From:
To: [DCAdmin](#)
Cc:
Subject: Objection by Local Resident to Application 2022/70/92570/W by Penistone Homes Ltd for variation of condition 1(Plans) on previous permission 2019/90727 (reserved Matters) application for 8 dwellings at 106 Greenfield Road Upperthong Holmfirth HD9 2LP
Date: 13 September 2022 19:34:43
Attachments:

8 Dwellings at 106, Greenfield Road, Upperthong Holmfirth, HD9 2LP

Objection by local resident to Application 2022/70/92570/W 8 dwellings at Variation of condition 1 (Plans) on previous permission 2019/90727 reserved Matters application pursuant to outline permission 2015/94106 for erection of 8 dwellings and demolition of existing dwelling

west elevation
scale 1:100

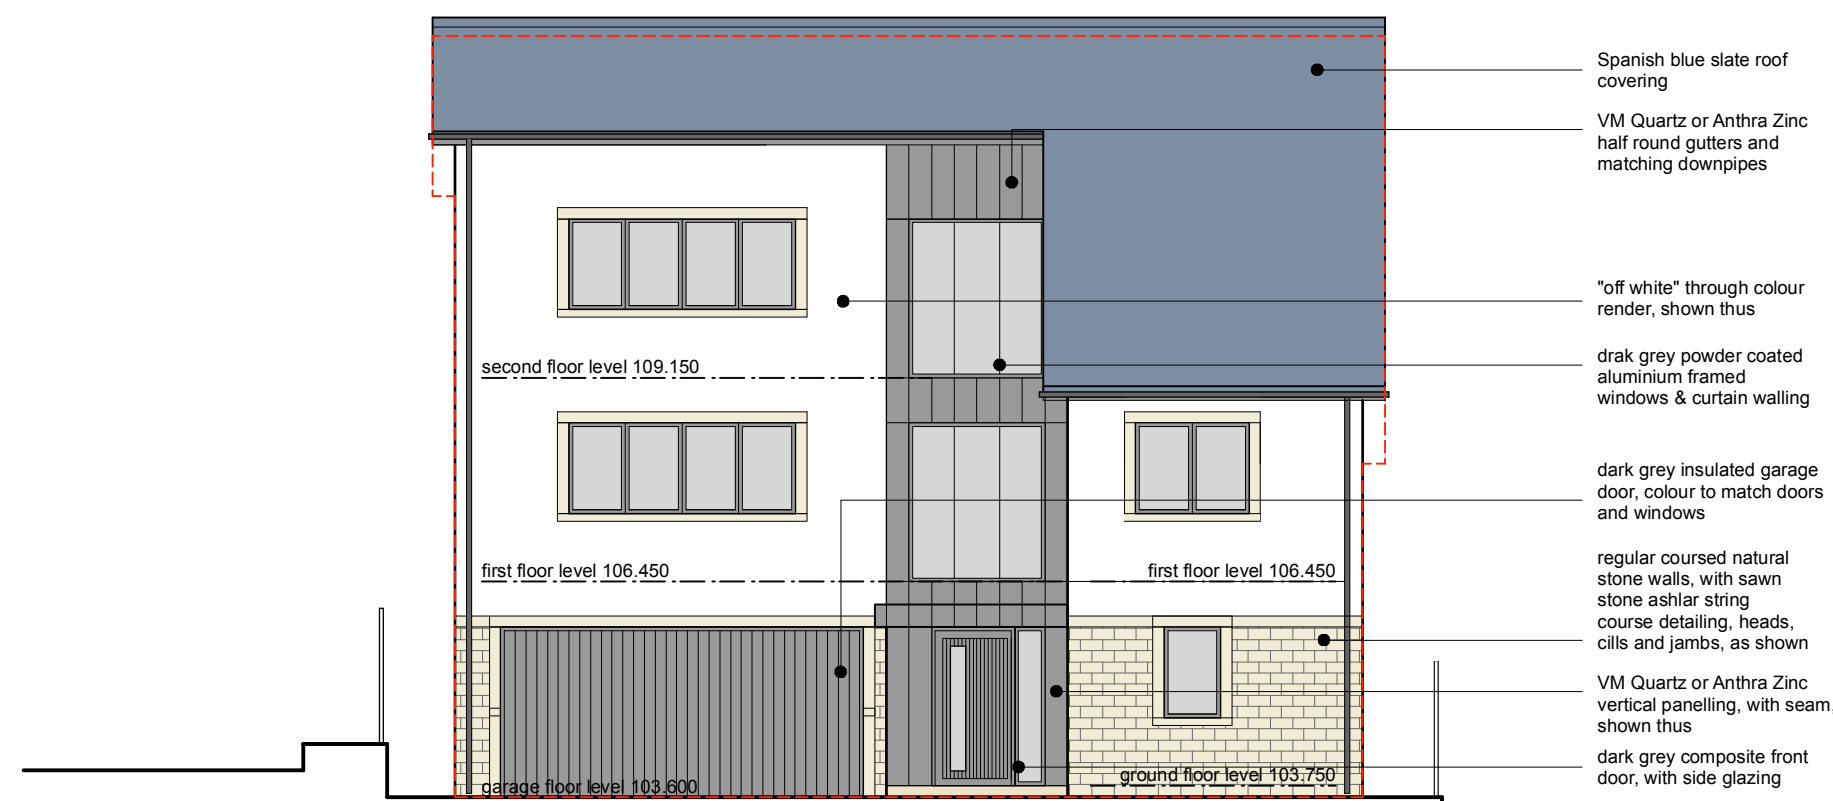
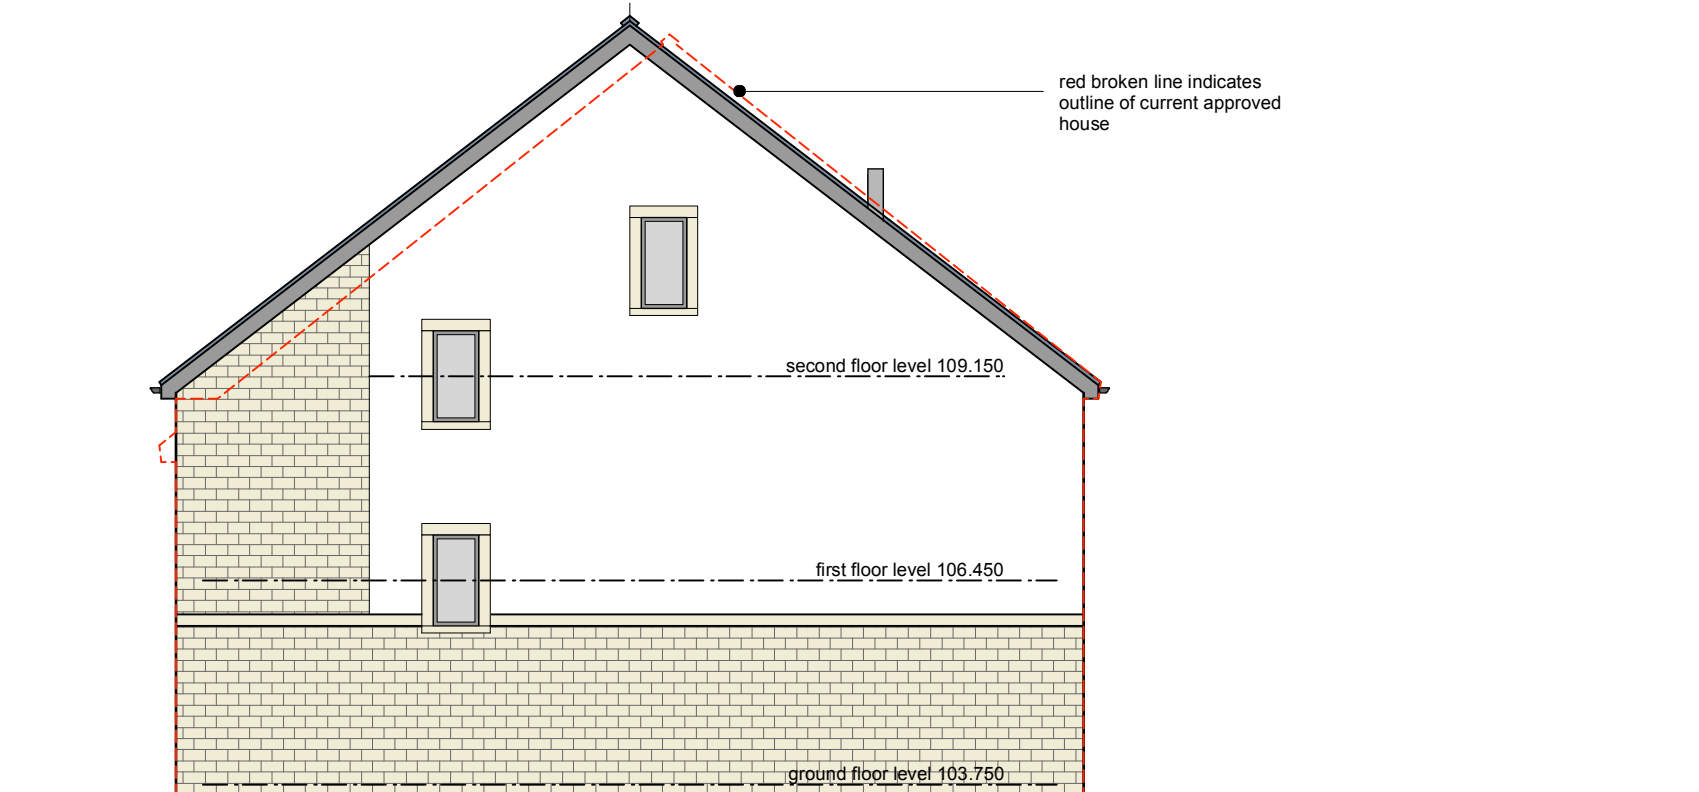
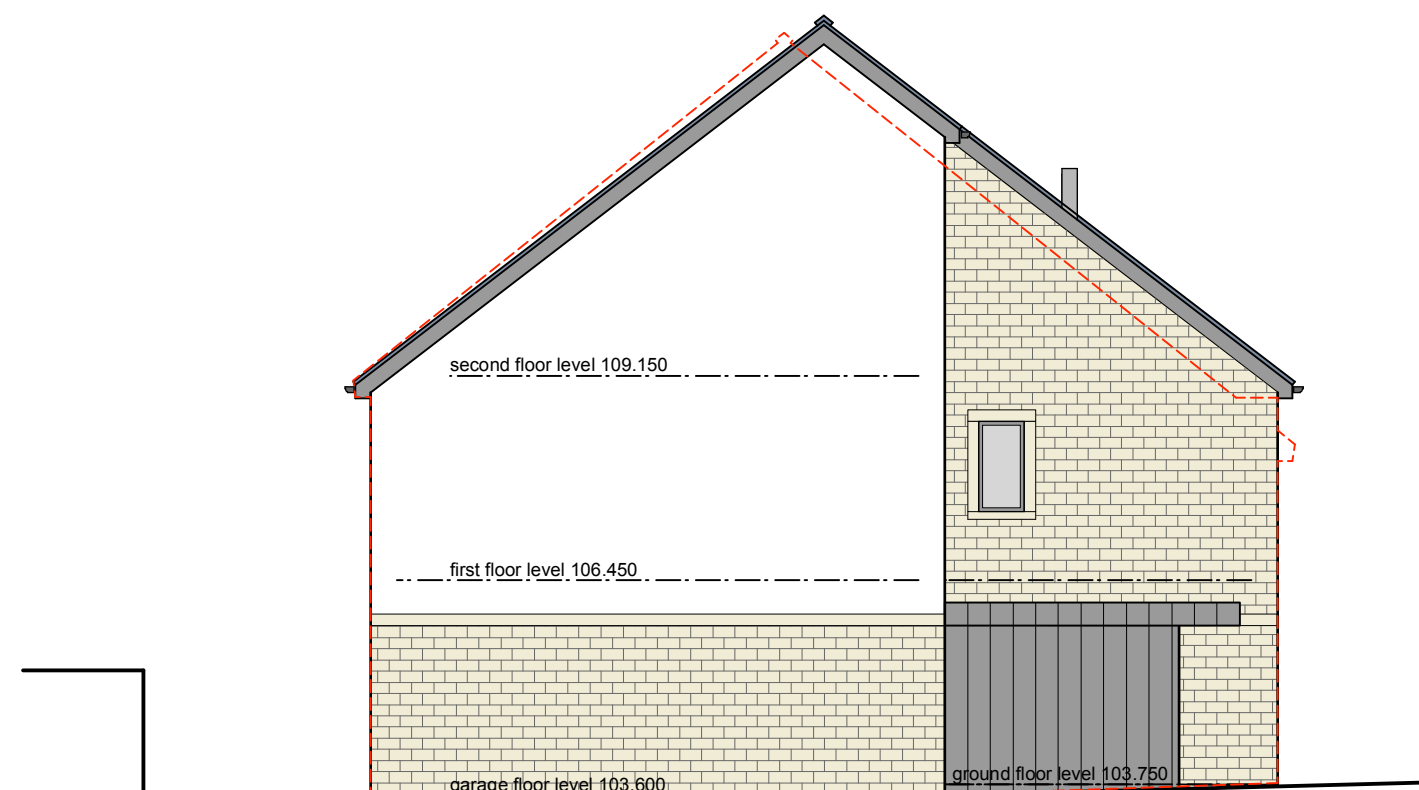
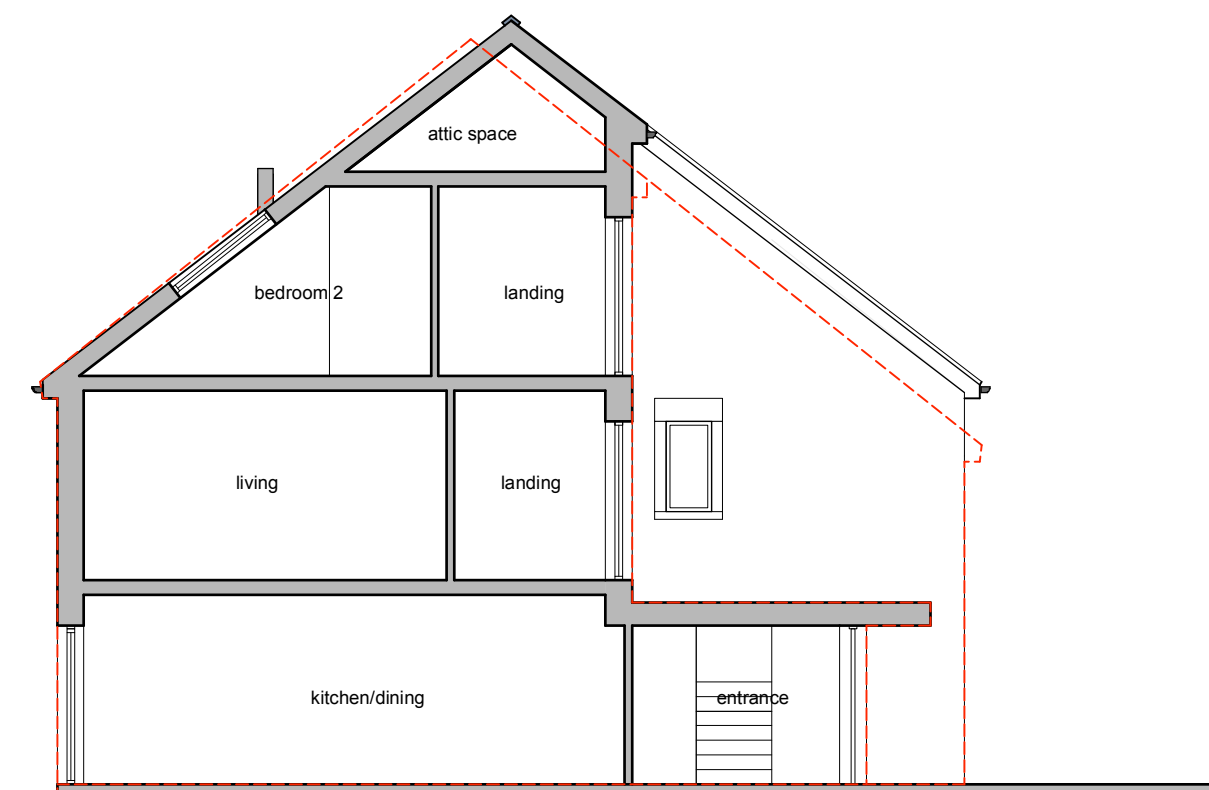
The scale of surrounding development is low-rise two-storey development. With the increases in ridge heights the proposed properties as built (plot 3) and under construction (plot 2) now approximate in height to that of a four-storey house. Buildings over two-storeys in this part of the Holme Valley are a rarity. Three and four storey Town Houses are seldom seen in Home Valley's rural villages.

The latest Penistone Homes application 2022/70/92570/W seeks to adjustments to the scale of the development of plots 2 and 3... the remaining 6 dwellings have yet to be started.

These changes include adjustments to the the configuration, volume, shape, height, length, slope/pitch/rake and

fenestration of the roofs of plots 2 and 3 – all of which are matters of scale.

We are told that the pitch of the roofs have been reduced and yet the ridge heights have increased. This being the case, we can only deduce that that the buildings must have “grown” in height beyond the approved finished floor levels. No other conclusion is mathematically and geometrically possible. If everything else remains unchanged then a reduction in the pitch or flattening of the roof must result in the ridge heights being lowered. If indeed the ridge heights have increased then the approved slab and/or finished floor levels are almost certain to have been overstepped.

front (west) elevations plots 4, 3 & 2 -
scale 1:200

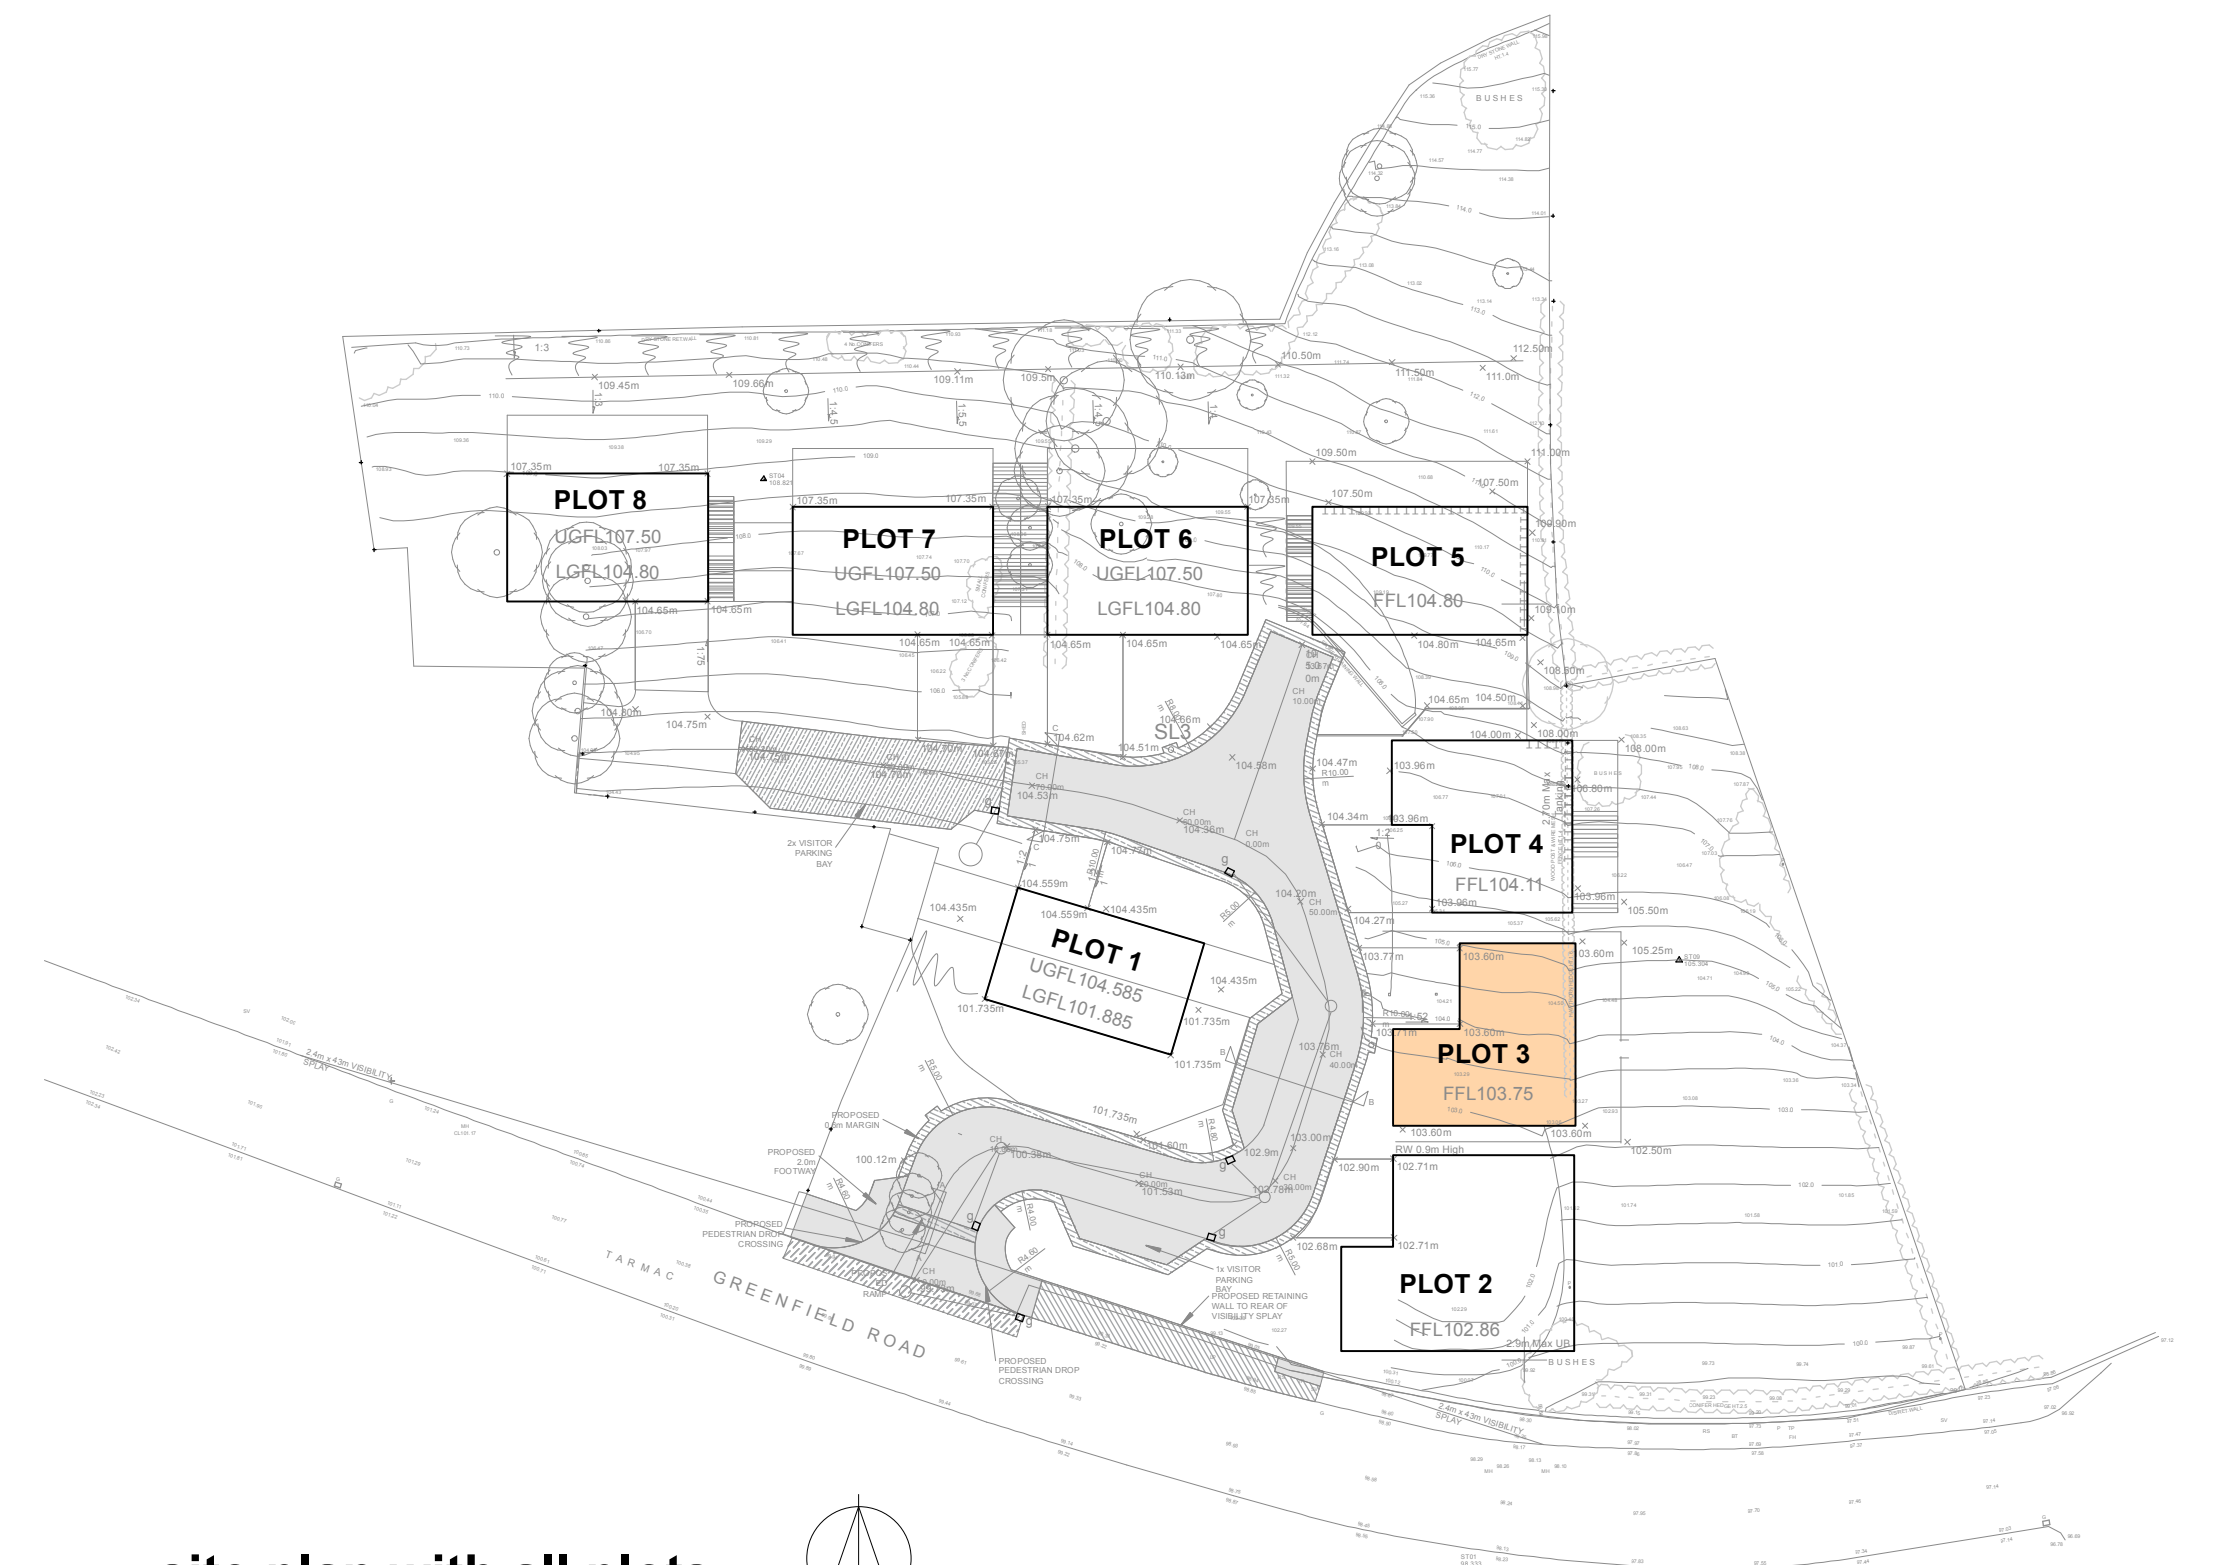
In our submission the development as built is both dominant as well as being wholly out of scale and out of character with the low rise humble cottages which constitute its immediate neighbours and which define the prevailing soundly-built, flat-fronted, stone-built, humble hillside-cottaged character of this part of the Holme Valley landscape. The dominance of plot 3 over its simpler stone cottaged neighbours is well illustrated by the photograph below:
